Application No: BE/46/21/PL
Site Address: 1 Sunningdale Gardens Bersted PO22 9LE
Description of works: Side and rear extension and divide into 2 No. 2 bed properties.

Thank you for your internet representation made on 12th August 2021 which has been recorded as an objection with the comments as follows:

Proposed Ground Floor Plan

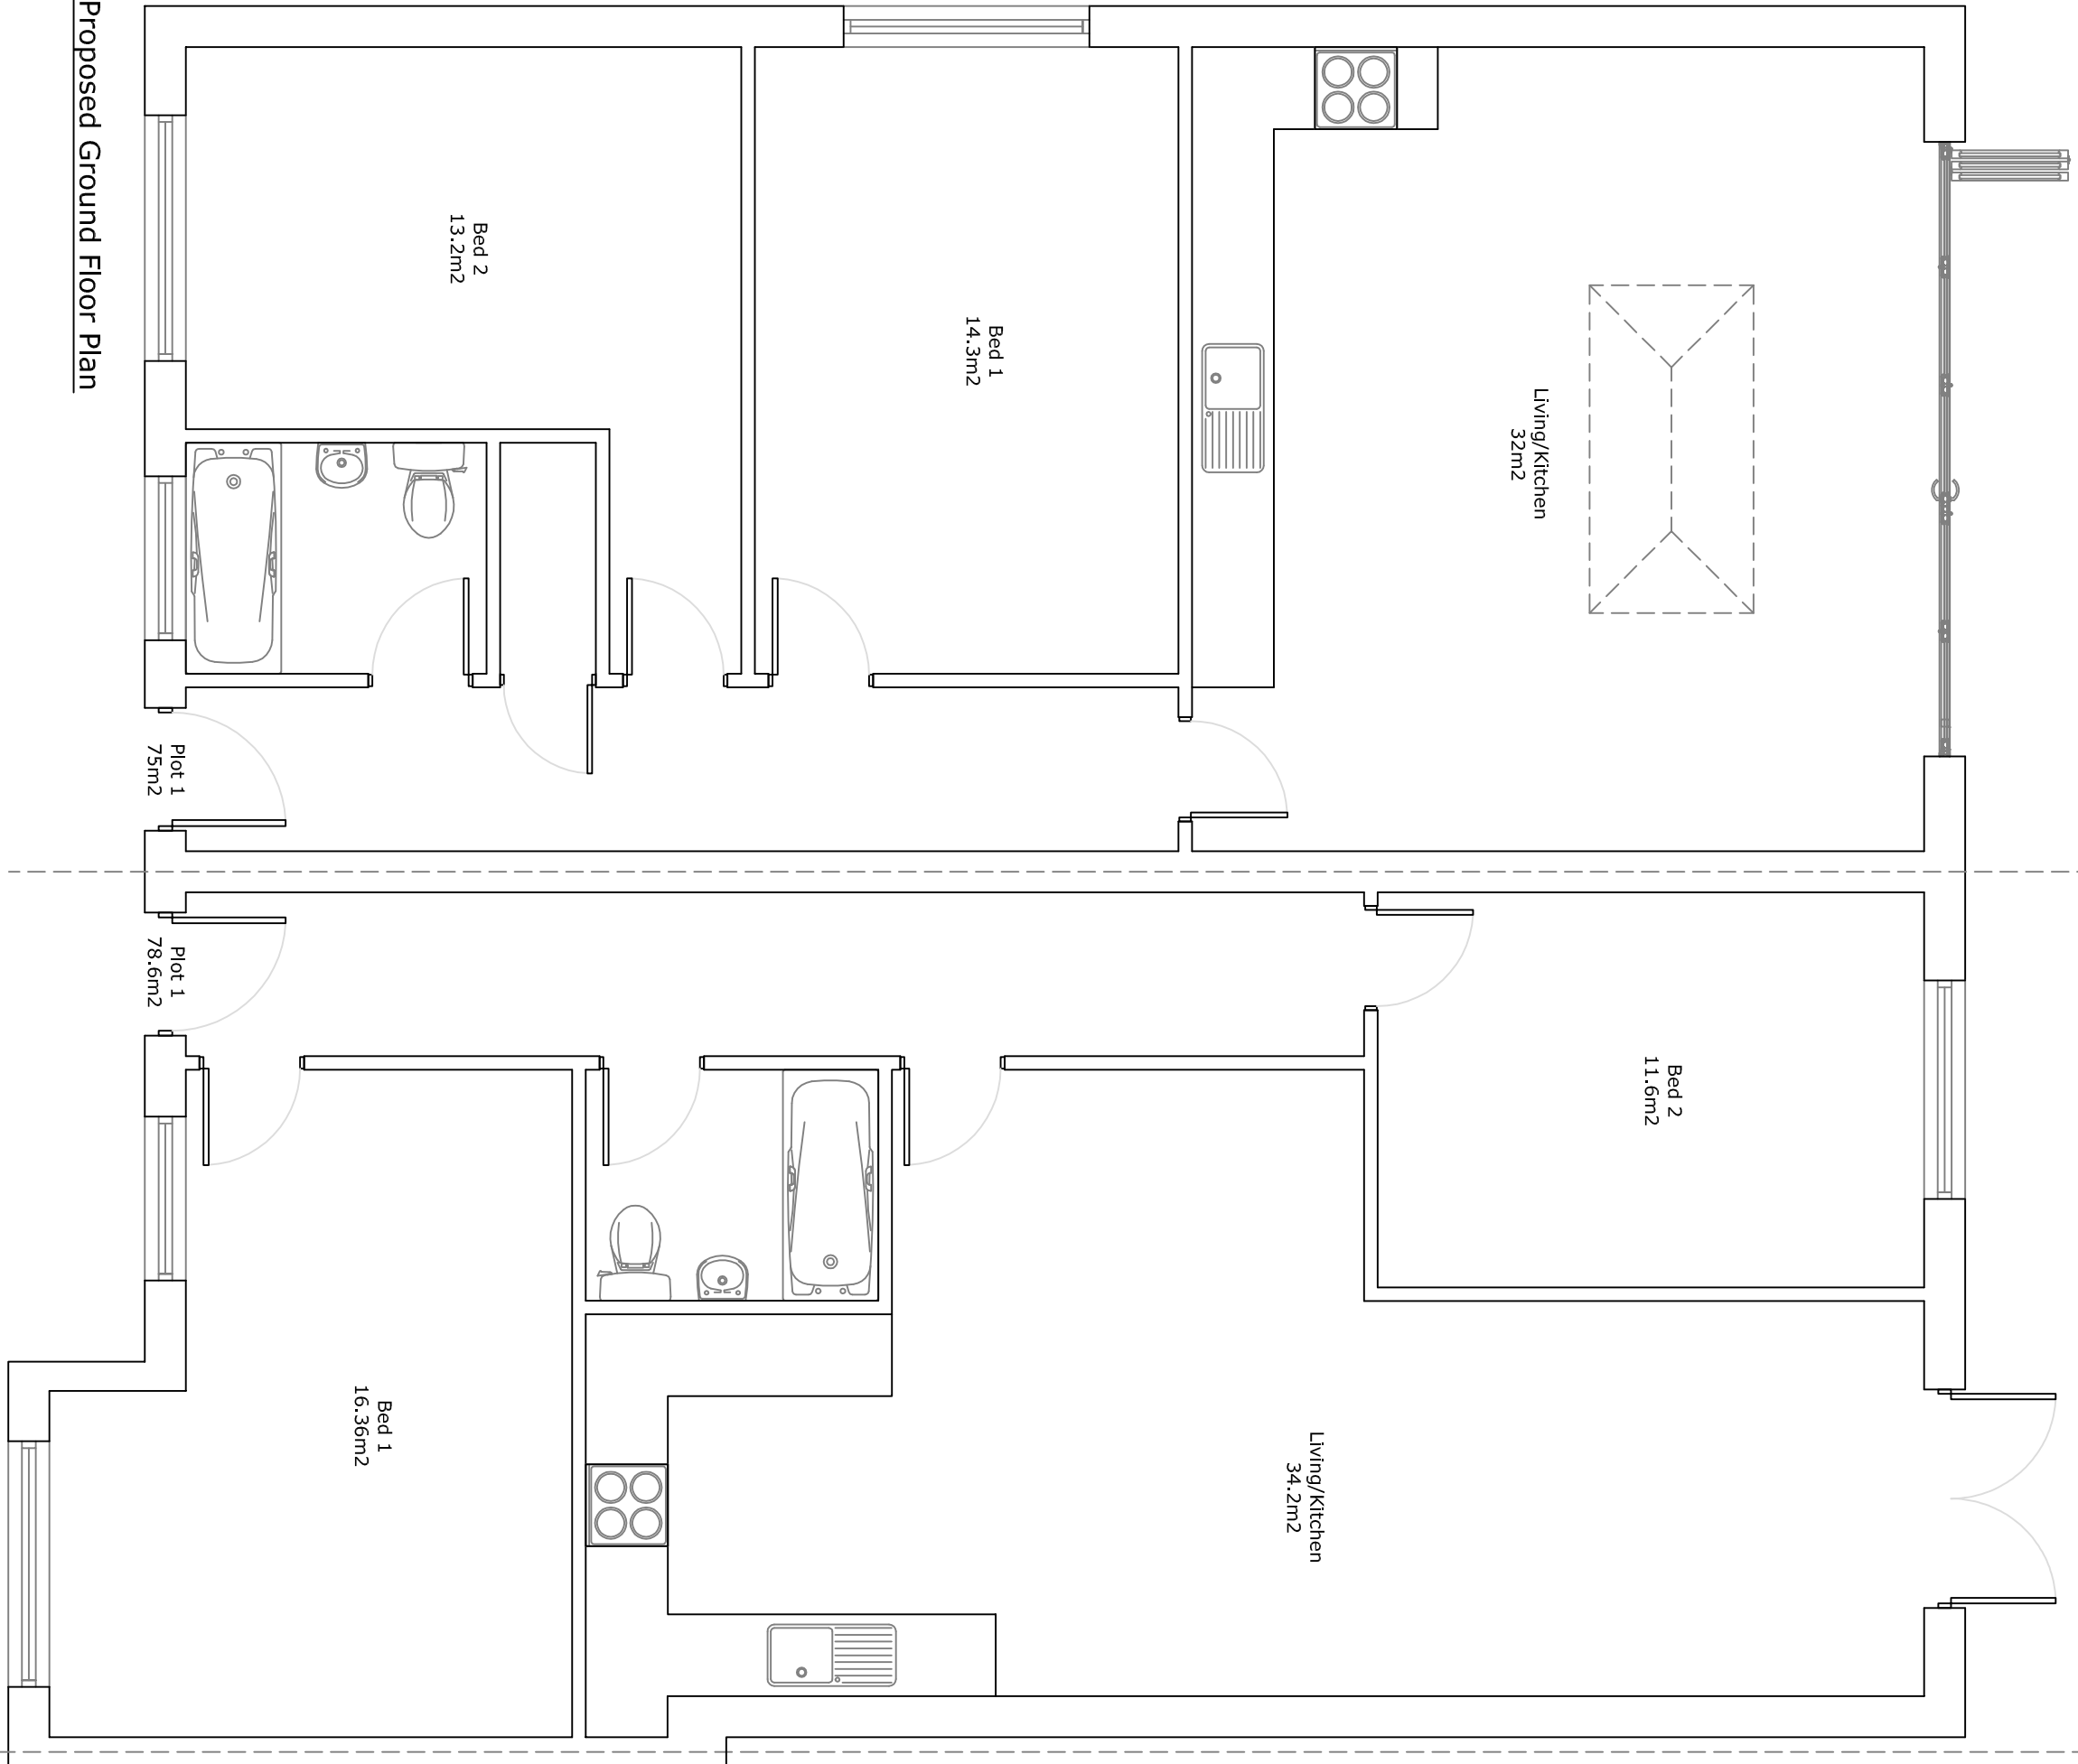
2. Within the plans submitted it does not currently illustrate a street lighting column which is located on the boundary in the middle of the proposed parking area which could create a risk and possible damage to the electrical services under the surface.
